## DECISION DELEGATED TO DEVELOPMENT MANAGER

**Application No:** H14-0607-20      **Applicant:** Anglia (UK) Ltd.

**Proposal:** Details of design and position of external boxes etc and means of foul water disposal (Conditions 3 and 5 of H14-0941-19)

**Location:** The Anglia Business Centre Mill Green Road Pinchbeck

Drawing No. 823-21_PL_BP02	Rev B
--------------------------------------	-----------------

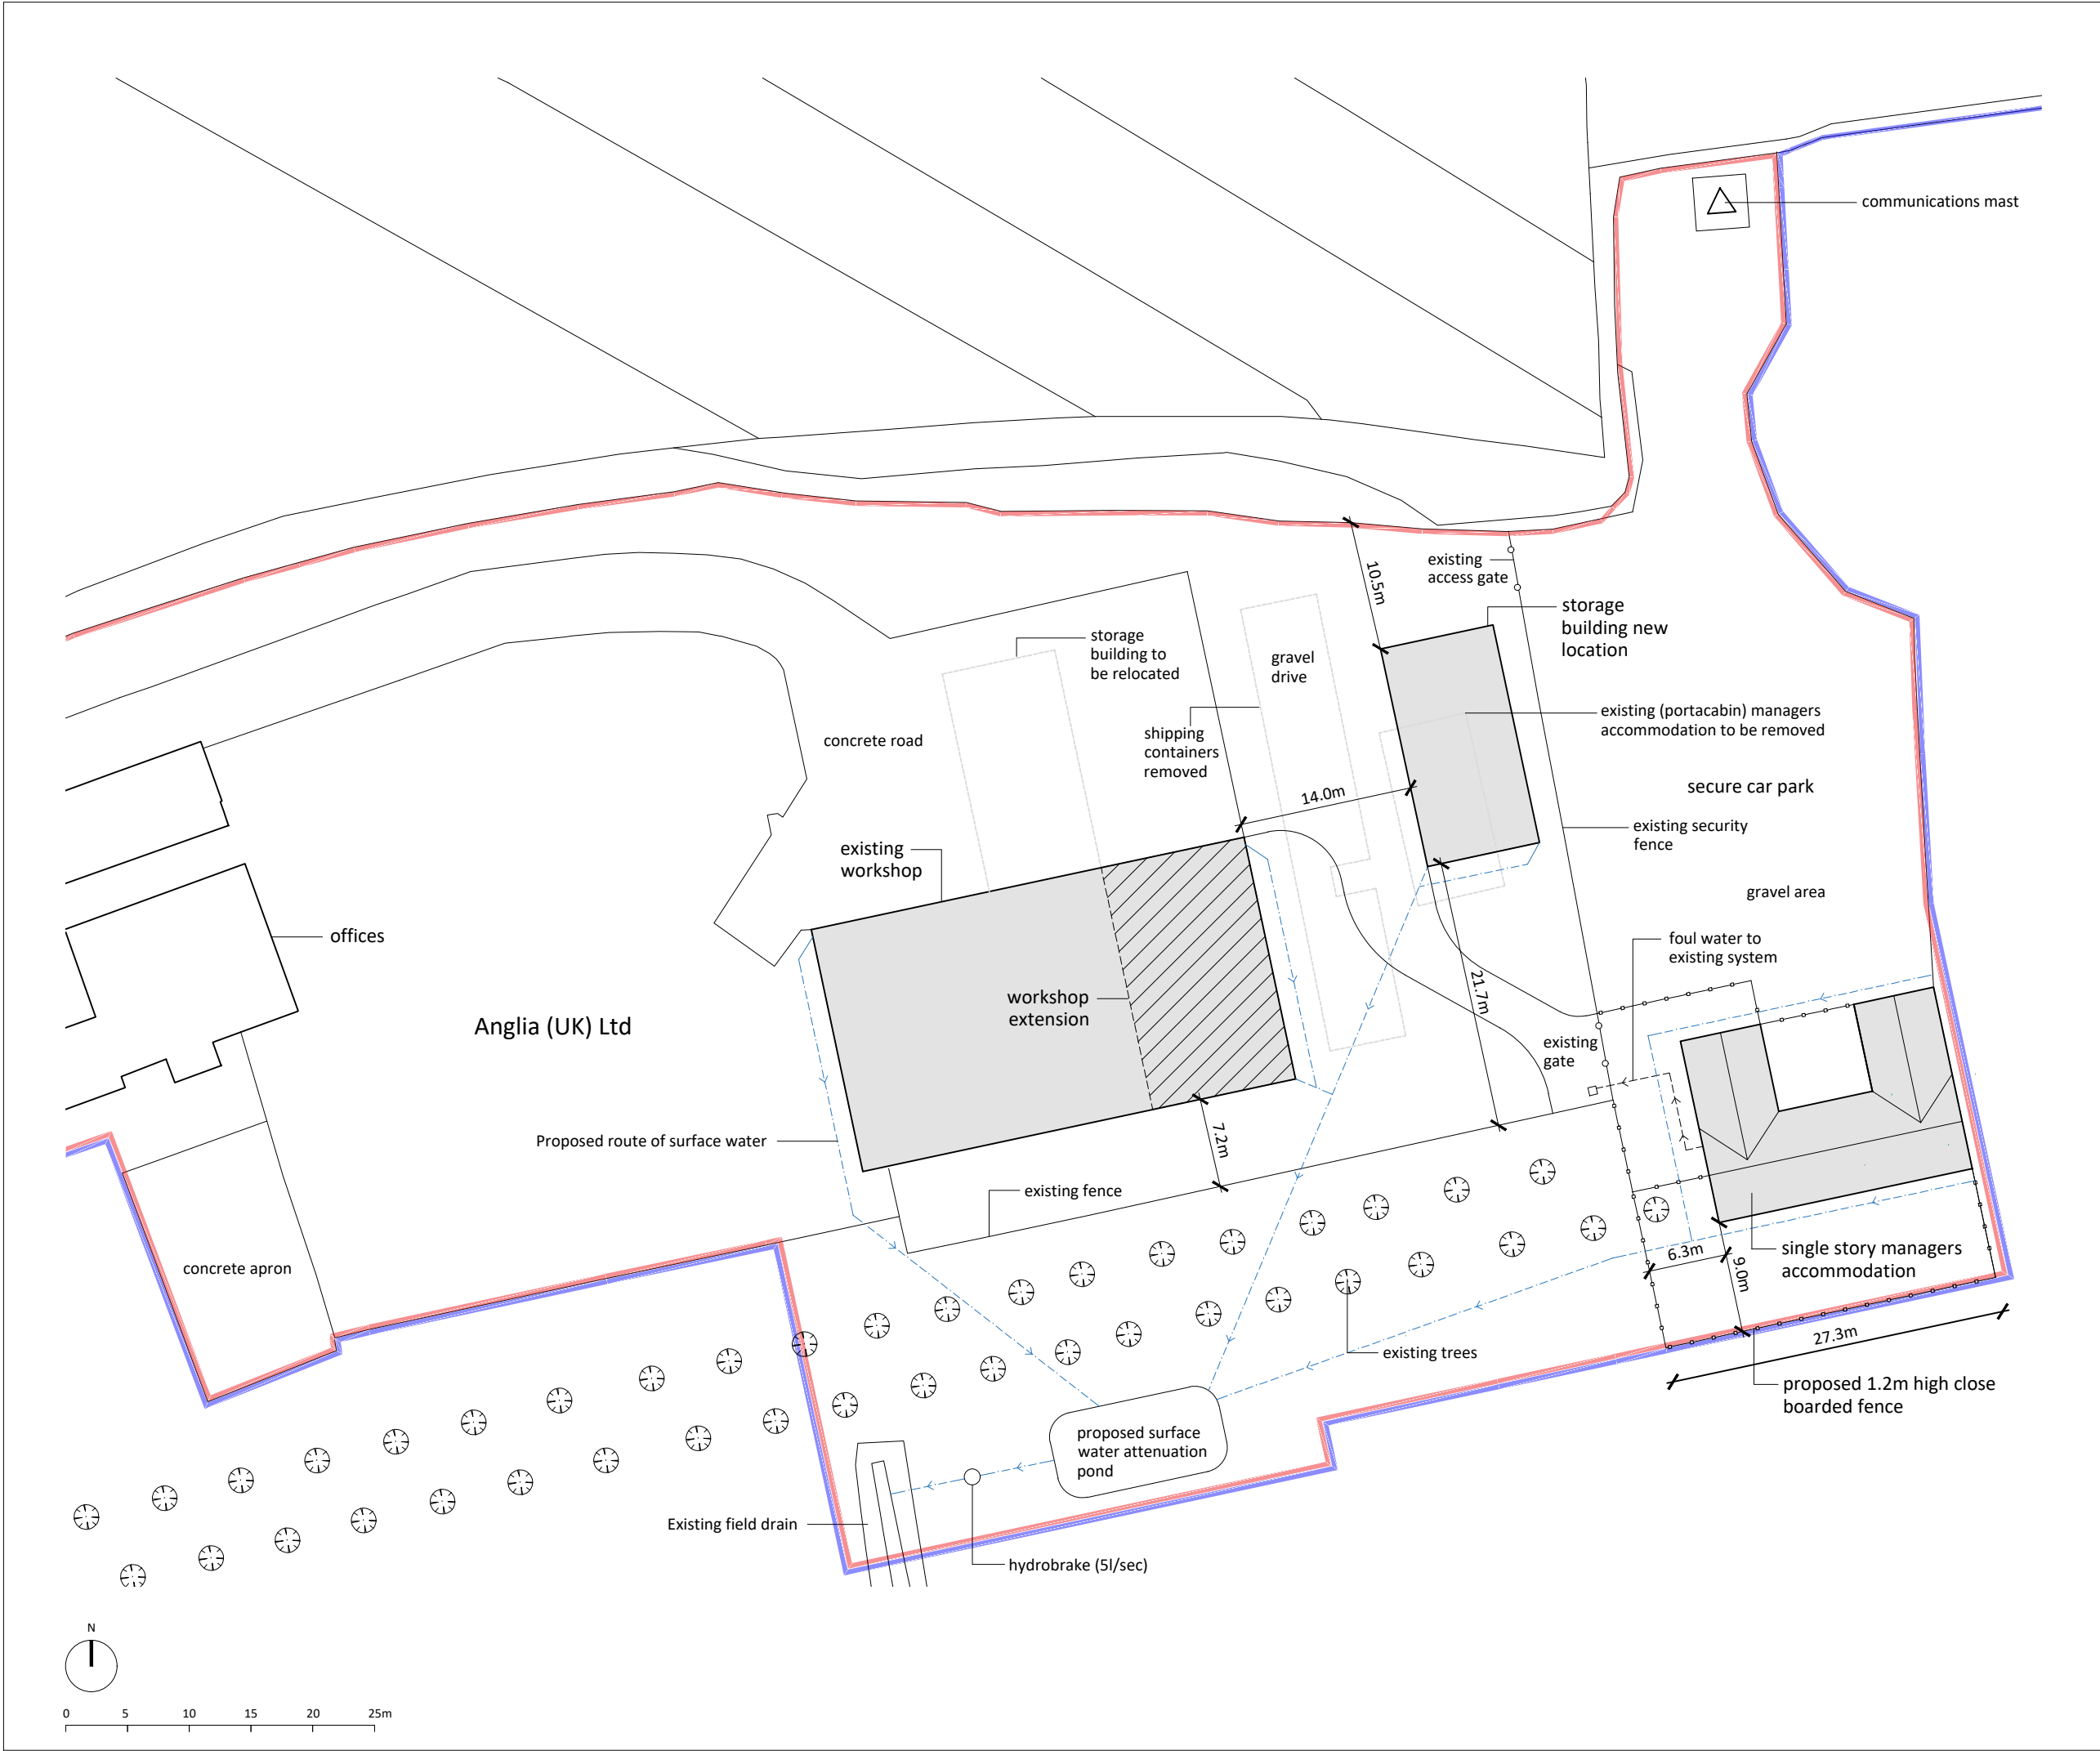
An attenuation pond is to be sited to the south of the existing workshop. This pond will feed into an existing field drain. Foul water provision is to be connected to the existing system on site. The submitted details are considered to be appropriate for the site. This condition can now be discharged.

Drawing No. 823-21-PL_GA06	Rev A
--------------------------------------	-----------------

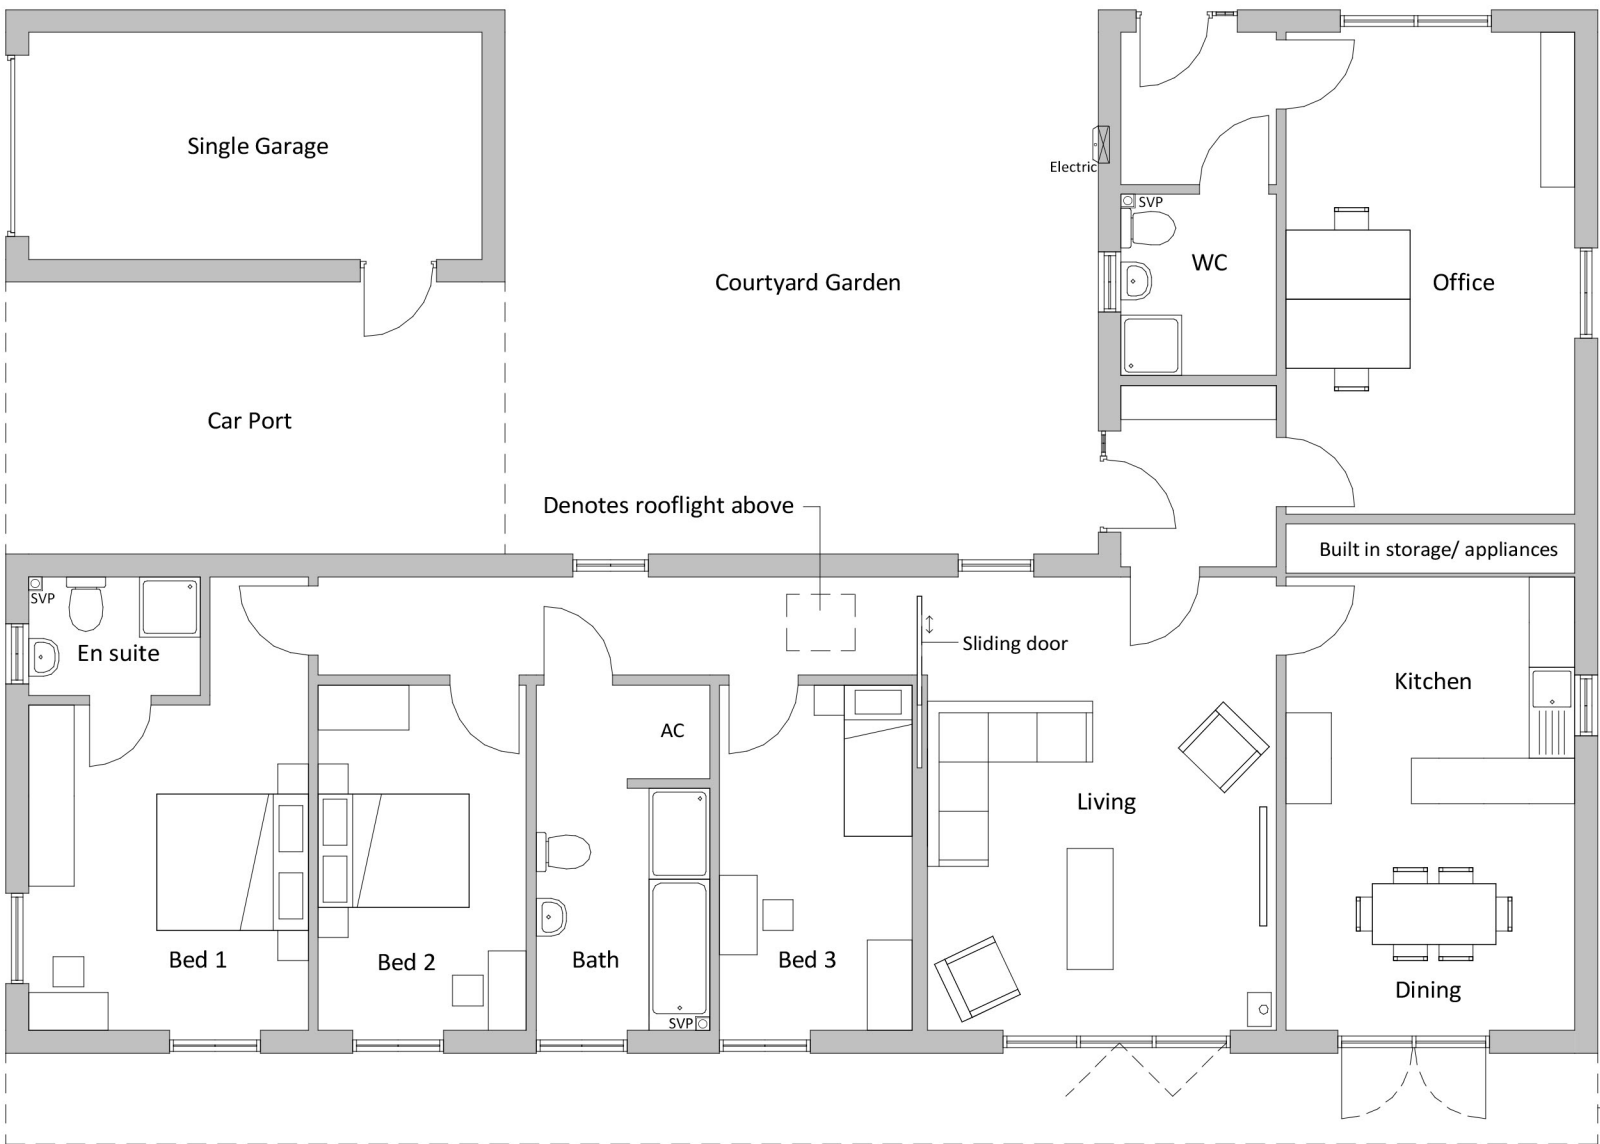
Services boxes are to be sited on the eastern and western elevations of the dwelling. The proposed locations are considered to be appropriate for the site. This condition can now be discharged.
